## Response to Planning application from Hertfordshire County Council (T and CP GDP Order 2015)

District ref: 6/2023/2345/FULL  
HCC ref: WH/19179/2023  
HCC received: 14 February 2024  
Area manager: Manjinder Sehmi  
Case officer: Natalie Ternent

Everest House Sopers Road Cuffley Potters Bar EN6 4SG

Erection of rear infill extension from ground to second floor with roof extension to create an additional floor and facade improvements to provide additional Offices (Class E)

Drawing Title:		Project Name:		Client:	
<b>Proposed Ground &amp; First Floor Plan</b>		<b>Cuffley Place, EN6 4SG</b>			
Project No:	Drawing No:	Rev:	Scale:	Status:	Date:
<b>2304</b>	<b>00-201</b>	<b>P01</b>	<b>1:200@A3</b>	<b>PLANNING</b>	<b>06.11.23</b>

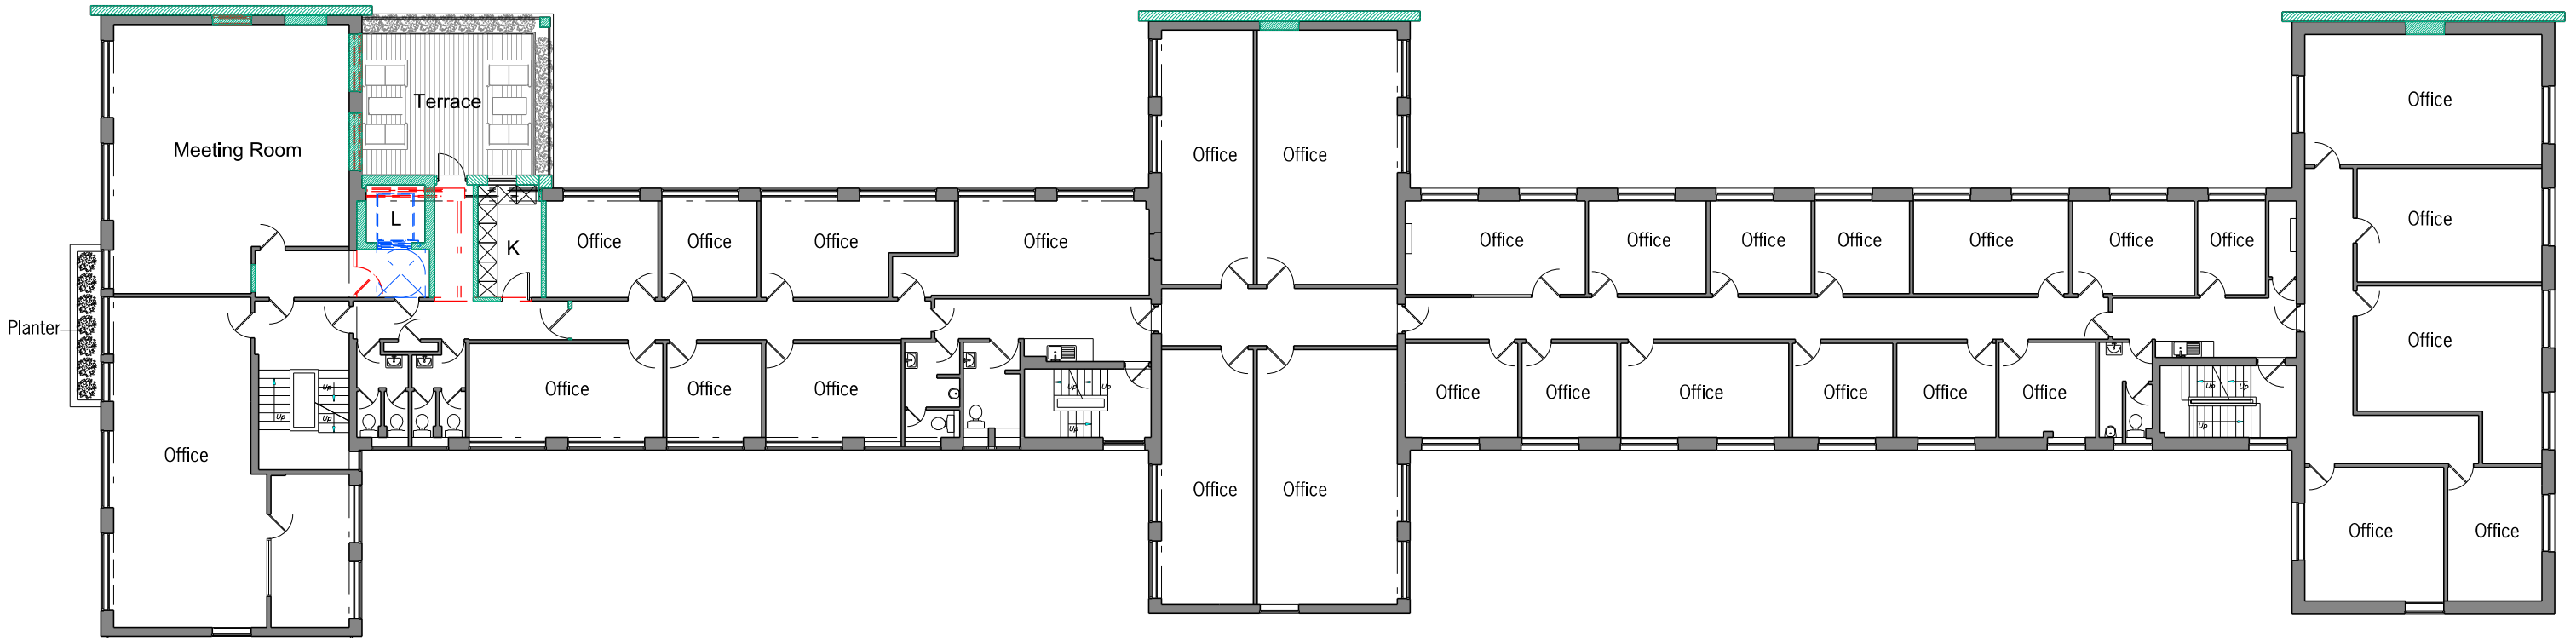
Drawing No. 00-201 Rev P01 highlights the location of the cycle store but confirmation on the number of spaces proposed is requested, particularly because the application form states that the proposed development will not increase or decrease employee numbers, which should be clarified in light of the nature of the proposed development.
